Cherry Orchard Point

Quality Audit

JOB NUMBER: 230062			DOCUMENT REF: 230062RPT002_QA_Rev_1			
Revision	Purpose Description	Originated	Checked	Reviewed	Authorised	Date
1	Final Issue	MD	CJP	MD	MD	19 Oct 2023
0	Draft Issue	MD	CJP	MD	MD	11 Aug 2023

Title: **ROAD LAYOUT SHEET 3 OF 3**

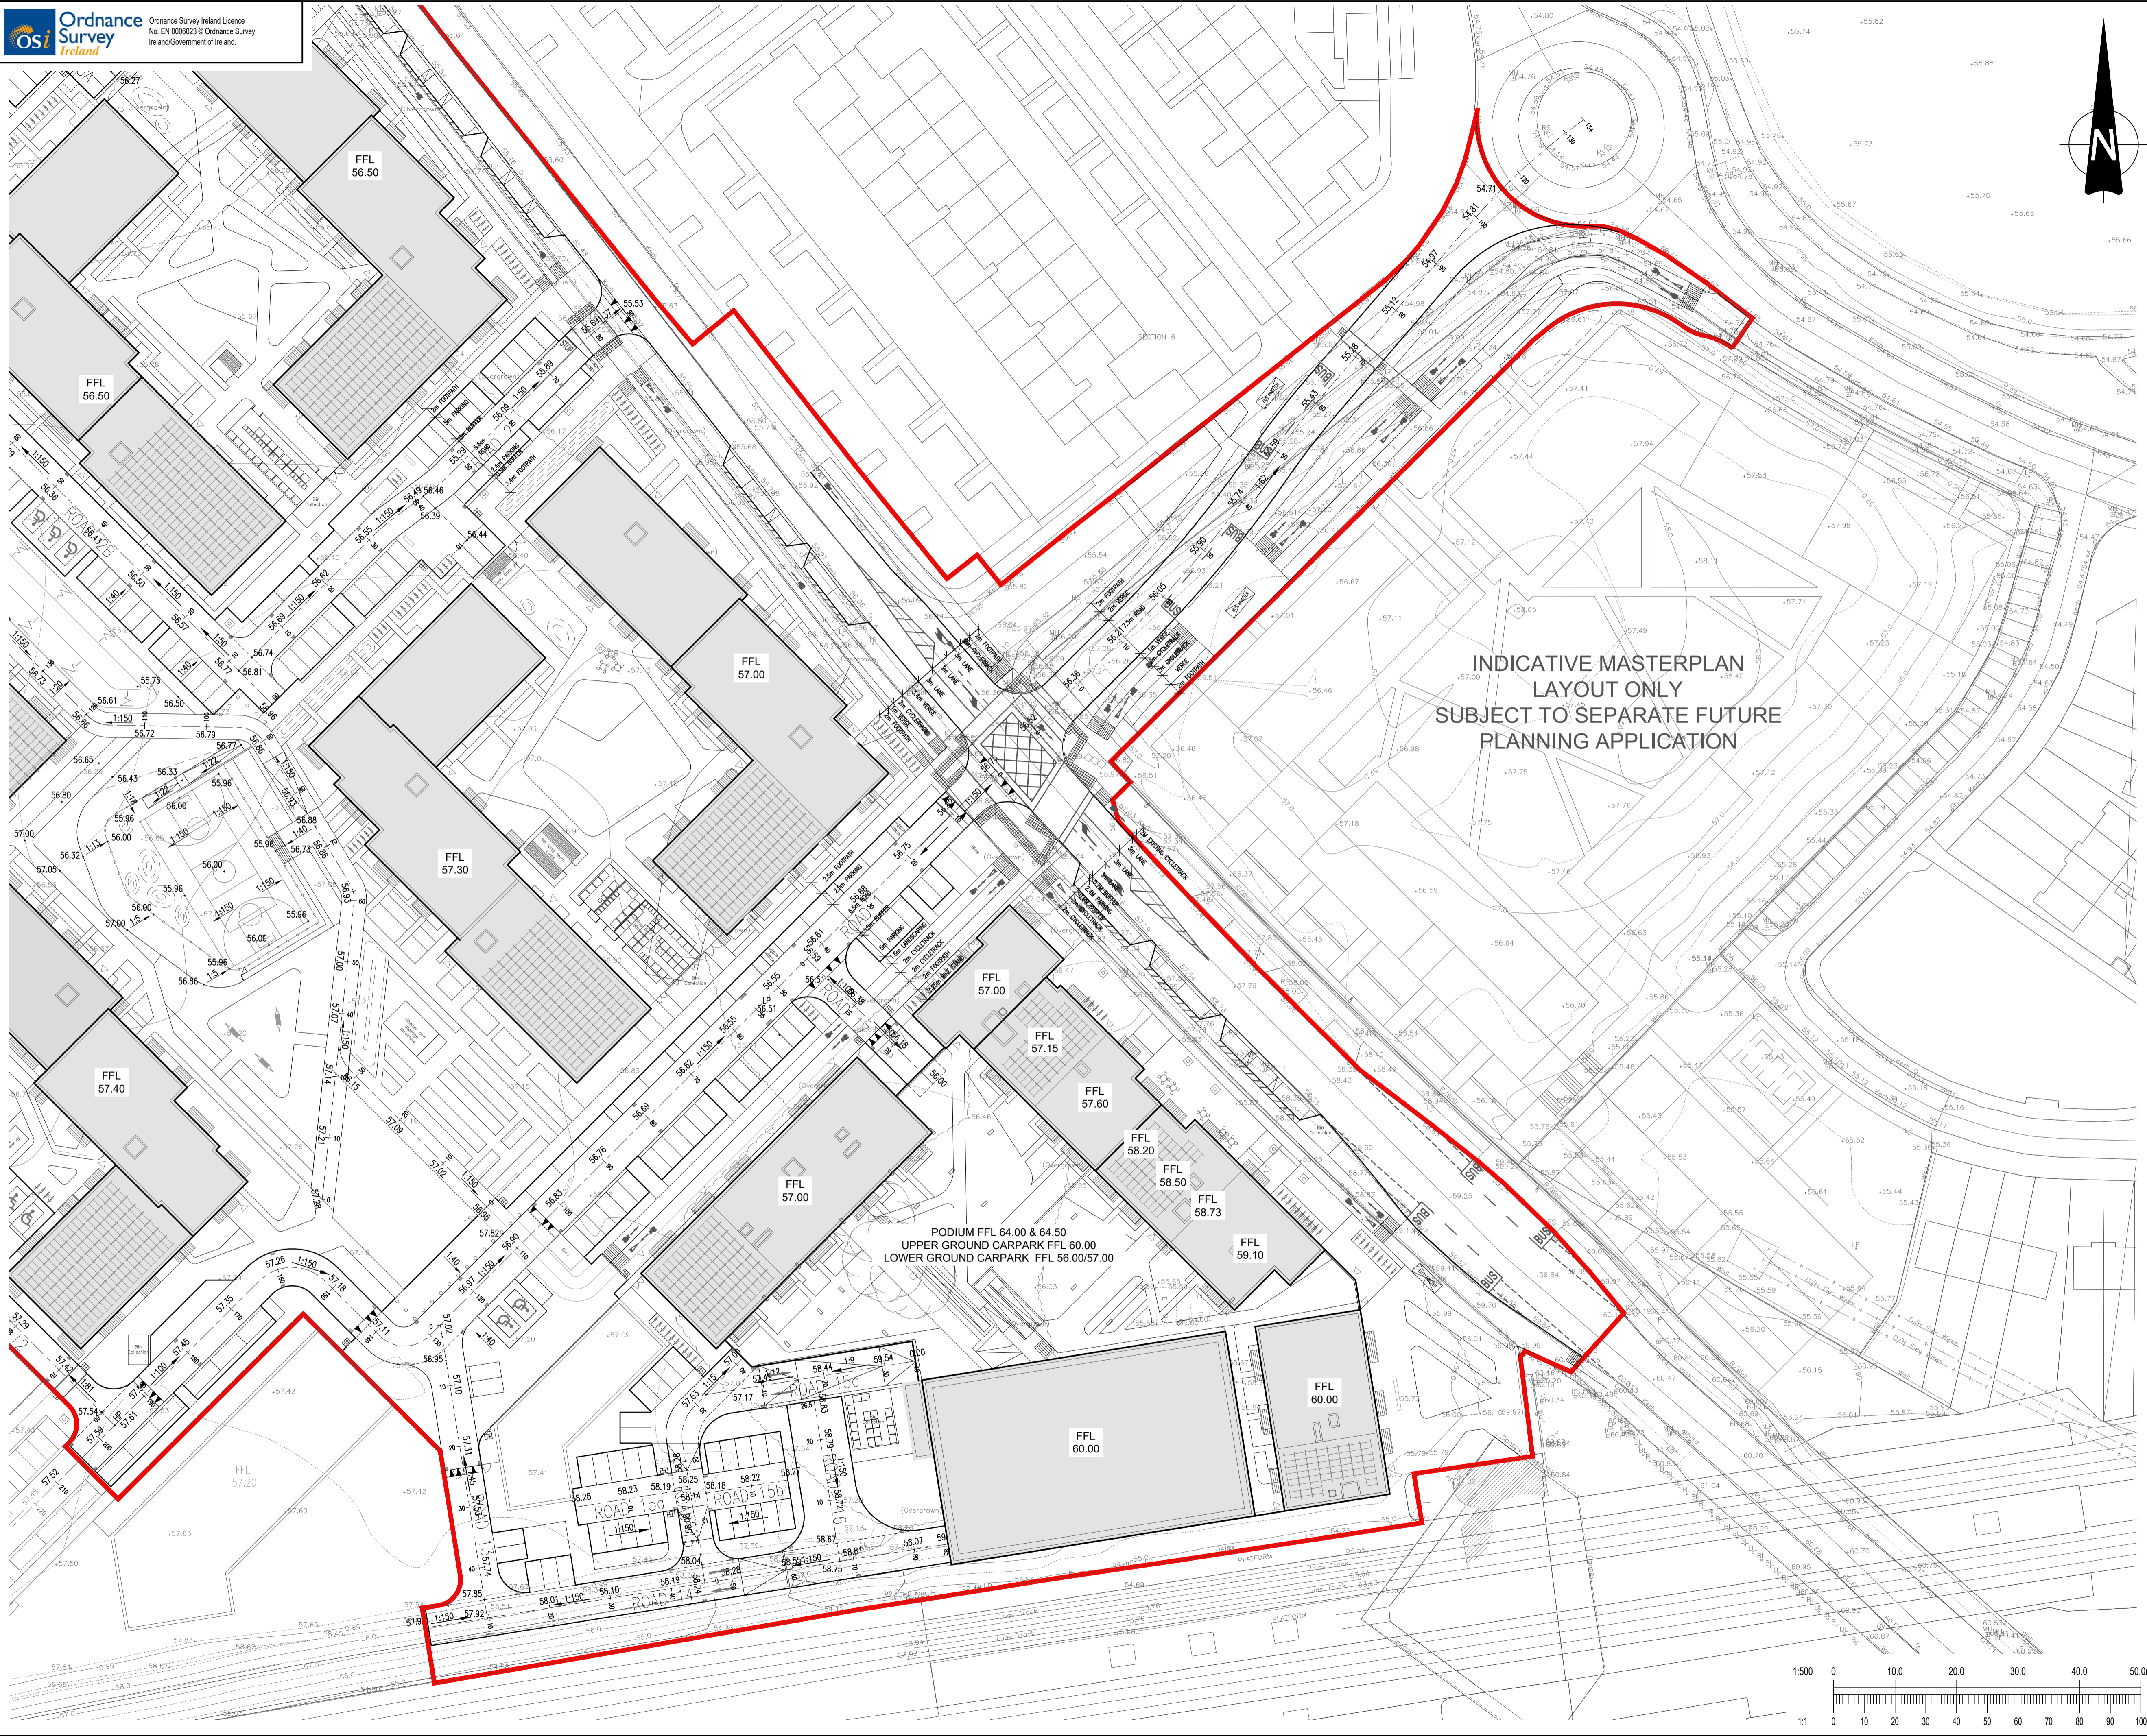
Drg. | Location: 103 | Crossing / Bus Stop on Cedar Brook Way

The proposed pedestrian courtesy crossing appears to terminate in the existing Northbound bus stop. This could result in conflict between crossing pedestrians and approaching buses.

An appropriate amount of separation should be provided between the proposed pedestrian crossing and the bus stop.

3.6	Yes	Yes	<p>The proposed pedestrian crossing has been relocated to a suitable location and out of the bus stop zone. Please refer to Drawing Number: 22-010-P103.</p> 	Comment noted.

Drg. | Location: 103 | Park West Avenue & Cedar Brook Way

The provision of cycle tracks at these location does not appear to retain any space for the existing footpath and therefore pedestrian progression. This could lead to a pedestrian walking in the cycle lane or the traffic lane, increasing their risk of conflict and injury.

Appropriate footpath facilities should be provided at the locations described.

3.5	Yes	Yes	<p>The proposed pedestrian and cycling connection to the existing infrastructure has been revised.</p> <p>The proposed infrastructure now ties in more clearly to the existing. Where cycle lanes end, tactile paving and signage will be provided advising of this and drop kerbing will be installed facilitating cyclist connectivity to rejoin the road surface and cycle lanes.</p> <p>Please refer to Drawing Number: 22-010-P010.</p>	Comment noted.

Title
PROPOSED ROAD JUNCTION SIGHTLINES

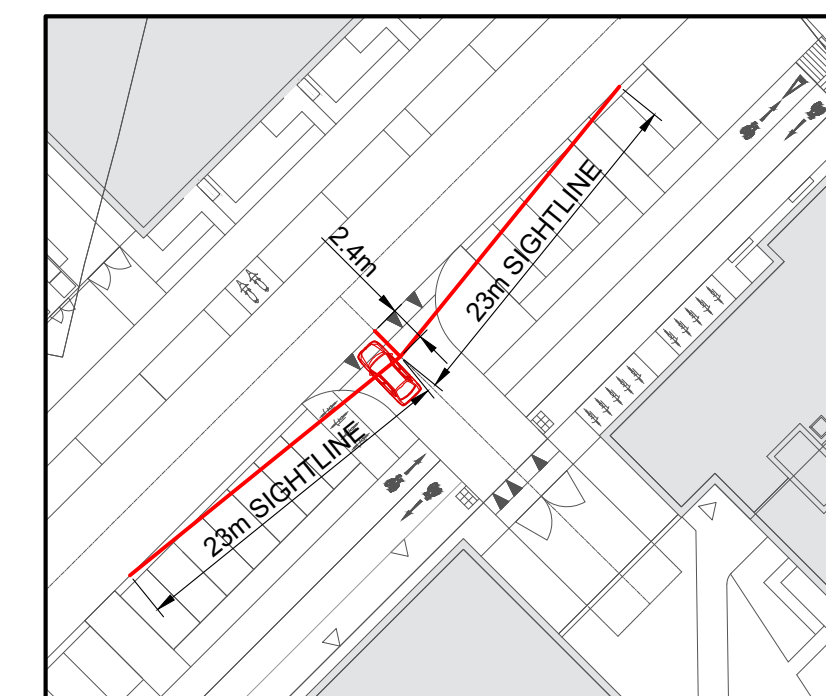
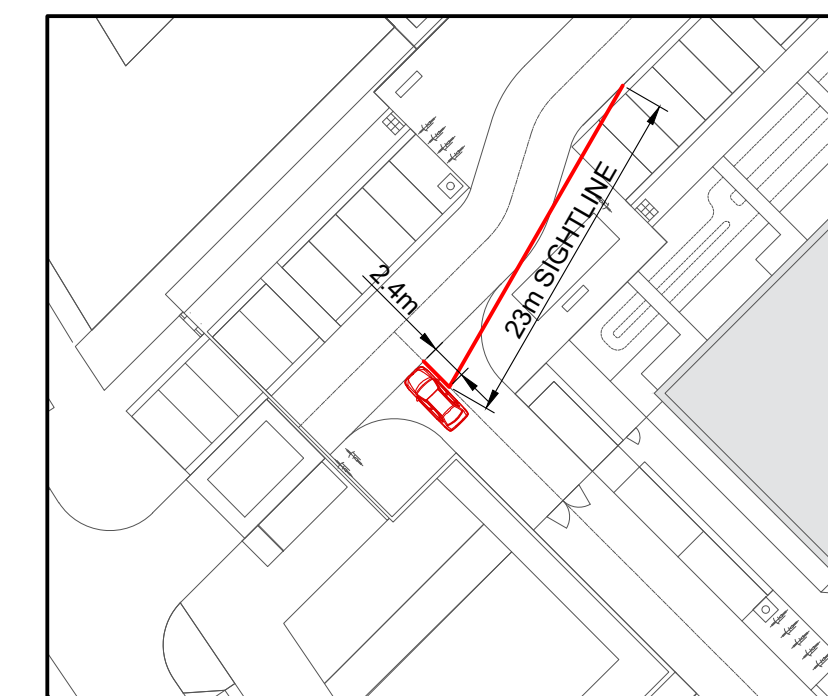
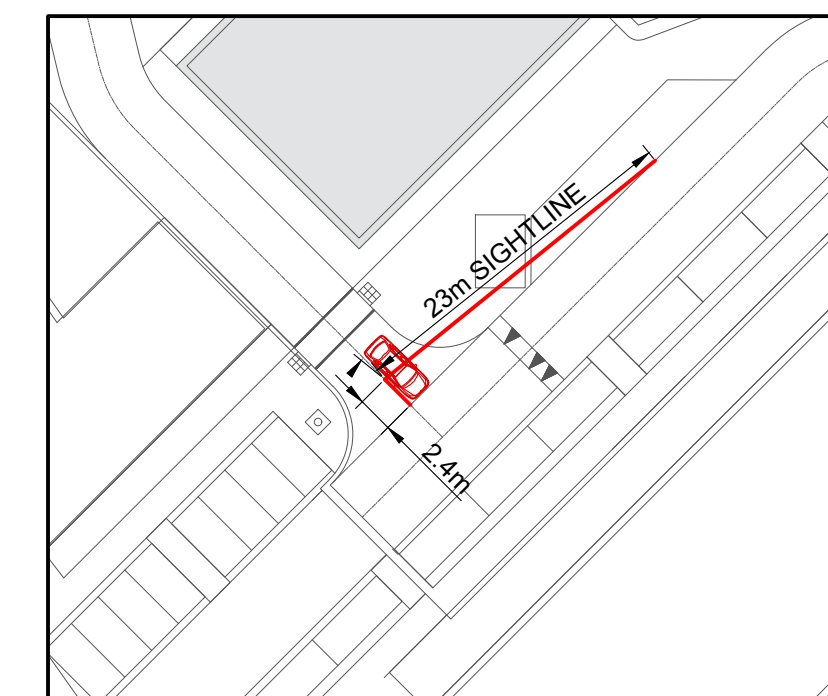
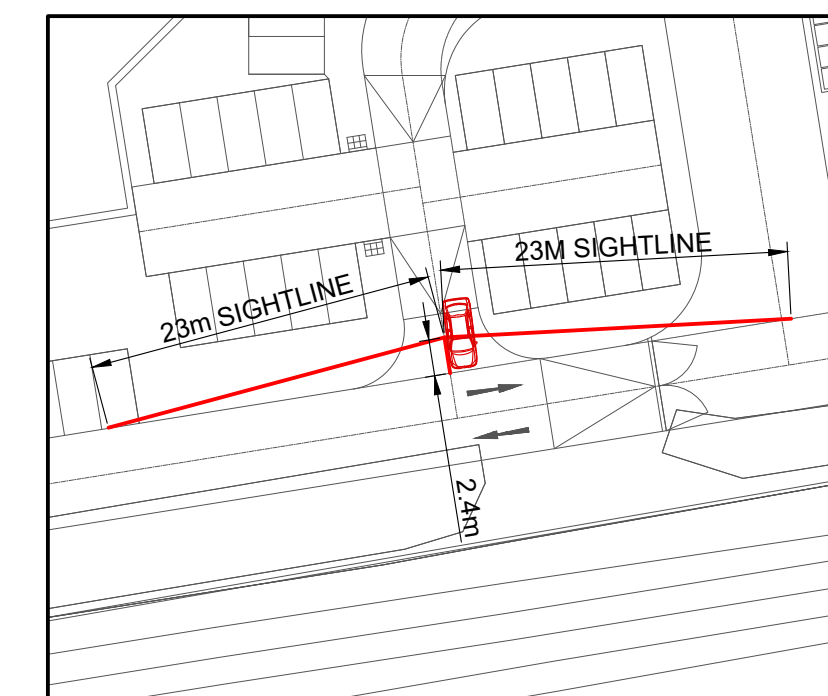
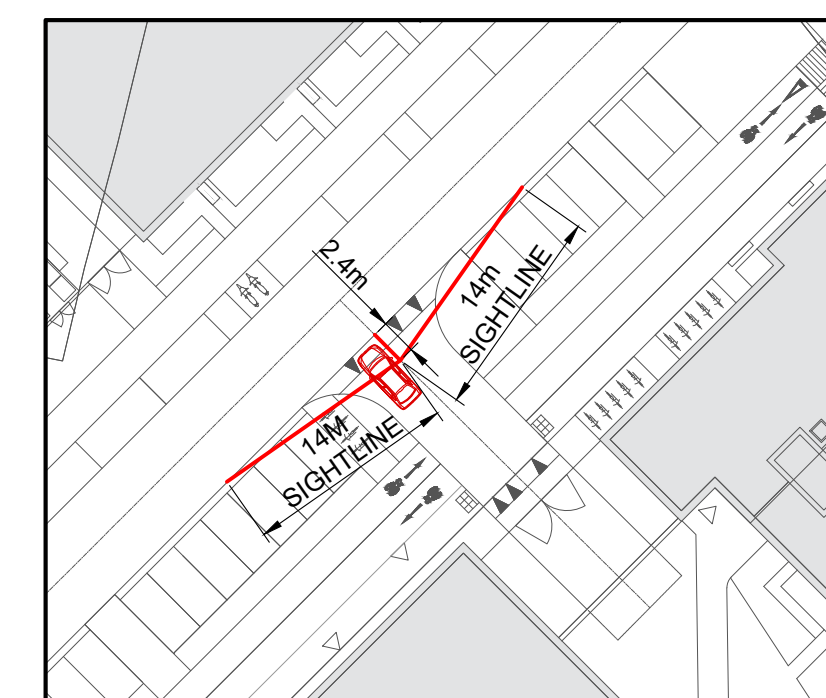
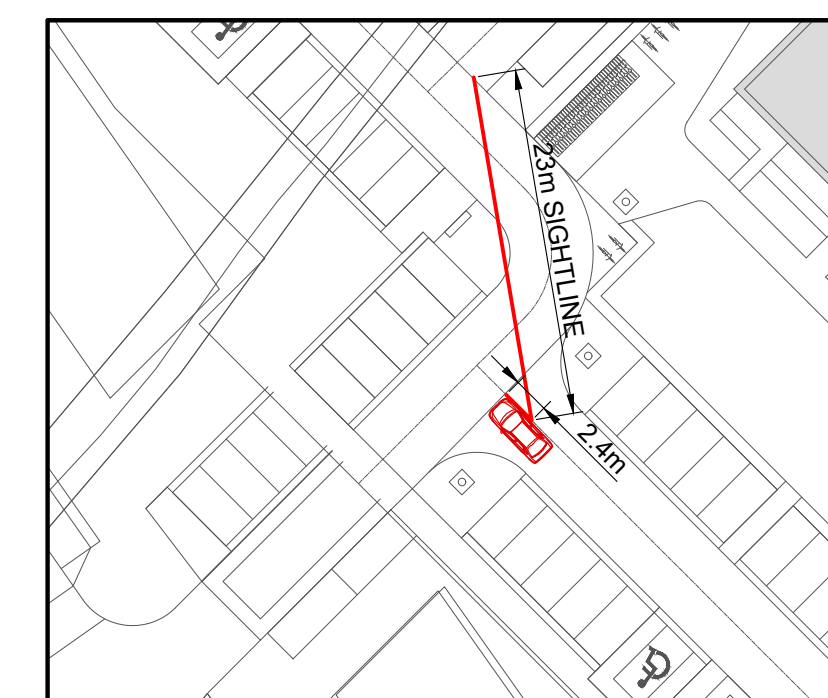
Drg. | Location: P101, P102, P103 | Priority Controlled Junctions

The proximity of parking spaces to an adjacent priority controlled junction could result in a parked car (or high-sided van / SUV) obscuring the junction’s envelope of visibility. This is likely to increase the risk of conflict between all road users at the junction.

Parking spaces in proximity to all priority controlled junctions should be checked and adjusted as appropriate to maximise each junction’s envelope of visibility.

3.2	Yes	Yes	<p>There are 3 No. priority junctions as part of the proposed development, 2 No. on Park West Avenue, and 1 No. entering/exiting the retail carpark.</p> <p>Sightline analysis has been undertaken on all these junctions.</p> <p>For the 2 No. priority controlled junctions on Park West Avenue, it is intended that the centreline roadmarkings will be formed by a solid white line, preventing overtaking. The sightline has been measured to the centreline of the road for traffic approaching the small arm of the junction from the left hand side. Visibility to vehicles approaching from the left is clearly facilitated.</p> <p>It is accepted that the sightlines do “clip” the parking bays on the right hand side to a certain extent however, the outline of a large family car (length 5.1m), indicates that the full sightline is provided. Visibility may be reduced in the event that high sided delivery vehicles occupy the space, and as such, temporary loading bays are facilitated elsewhere onsite to mitigate against this occurrence.</p> <p>For the junction entering/exiting the retail carpark, parking bays have been shifted to optimise visibility splays. It is noted that for a road design speed of 30KPH, full visibility of 23m is not provided, however, given the short length of straight road approaching this junction from the south (due to road curvature), and the north (from the junction) it is felt that a max achievable speed of 20KPH is more realistic and a required sightline of 14m for this design speed has been mostly achieved.</p> <p>Sightline analysis is shown in its full revision on Drawing Number: 22-010-P130.</p>	Comment noted.
